KITTITAS COUNTY

MEMORANDUM

TO: Jeff Watson, Community Development Services
FROM: Christina Wollman, Planner II *CW*
DATE: November 29, 2010
SUBJECT: Brain SG-10-00018

The Public Works Department has reviewed the Request for Parcel Segregation Application. In order to ensure that it meets current Kittitas County Road Standards, the applicant needs to provide the following prior to final approval:

RECORD OF SURVEY

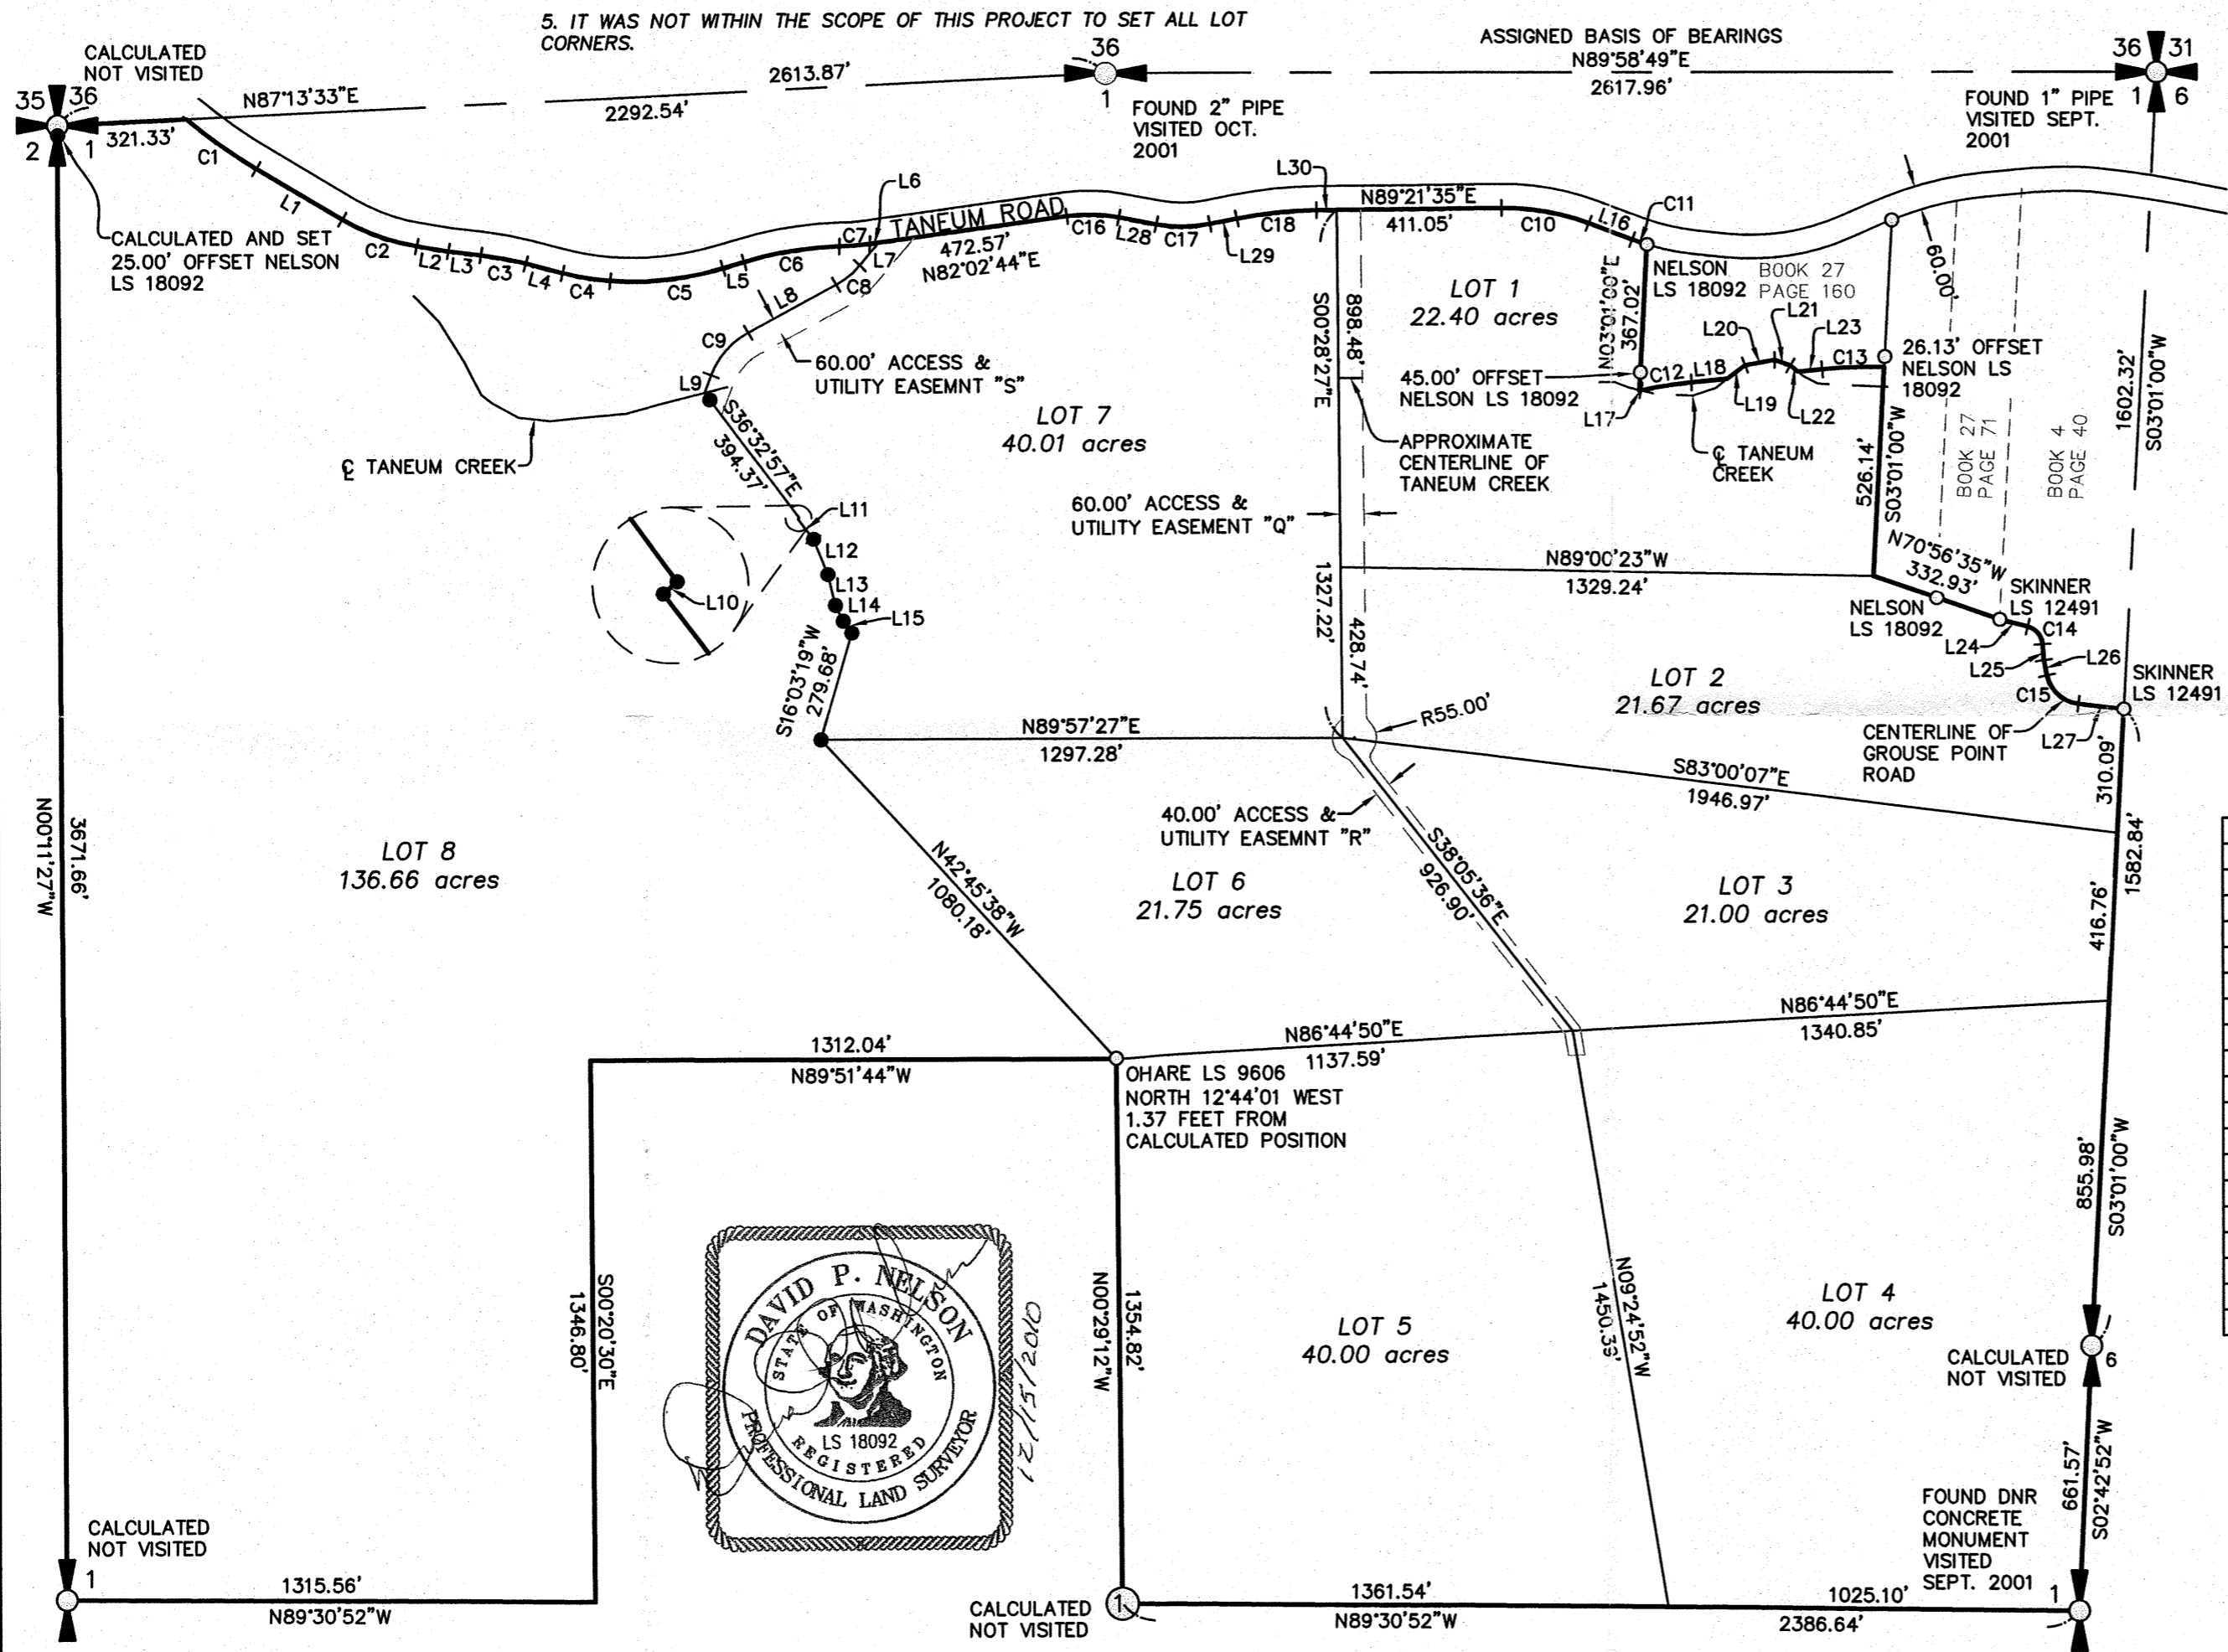
1. The applicant shall consult with Washington Department of Fish and Wildlife and any other interested agencies to determine if a crossing over Taneum Creek will be allowed at the proposed location to serve lots 1-6. Documentation shall be submitted to Public Works prior to final approval.
2. The proposed access with appropriate easement(s) shall be shown and shall conform to applicable Kittitas County Road Standards.
3. A survey that describes the final configuration of the subject property shall be required.

2. Proposed Access Location: Public Works has performed a preliminary review of the proposed access onto Lot 1. The access location appears to meet all spacing and site distance requirements. Prior to performing any work on the proposed approach, an access permit must be issued by Public Works. The access permit will detail construction requirements, which will include the construction of a landing with a grade of no more than +/- 6% for a distance of 20 feet from the edge of the pavement.

3. Access to Lots 3 and 4: Lots 3 and 4 must be accessed directly from the cul-de-sac. If the lots are to be accessed from a location beyond the cul-de-sac, the private road must be extended.

6. Cul-de-Sac: A cul-de-sac turn-around having an outside right-of-way easement diameter of at least 110 feet shall be constructed at the closed end of all dead-end roads serving 3 or more lots. The driving surface shall be at least 96 feet in diameter. Cul-de-sacs must also conform to the requirements specified by the 2006 International Fire Code. Contact the Fire Marshal regarding any additional cul-de-sac requirements.
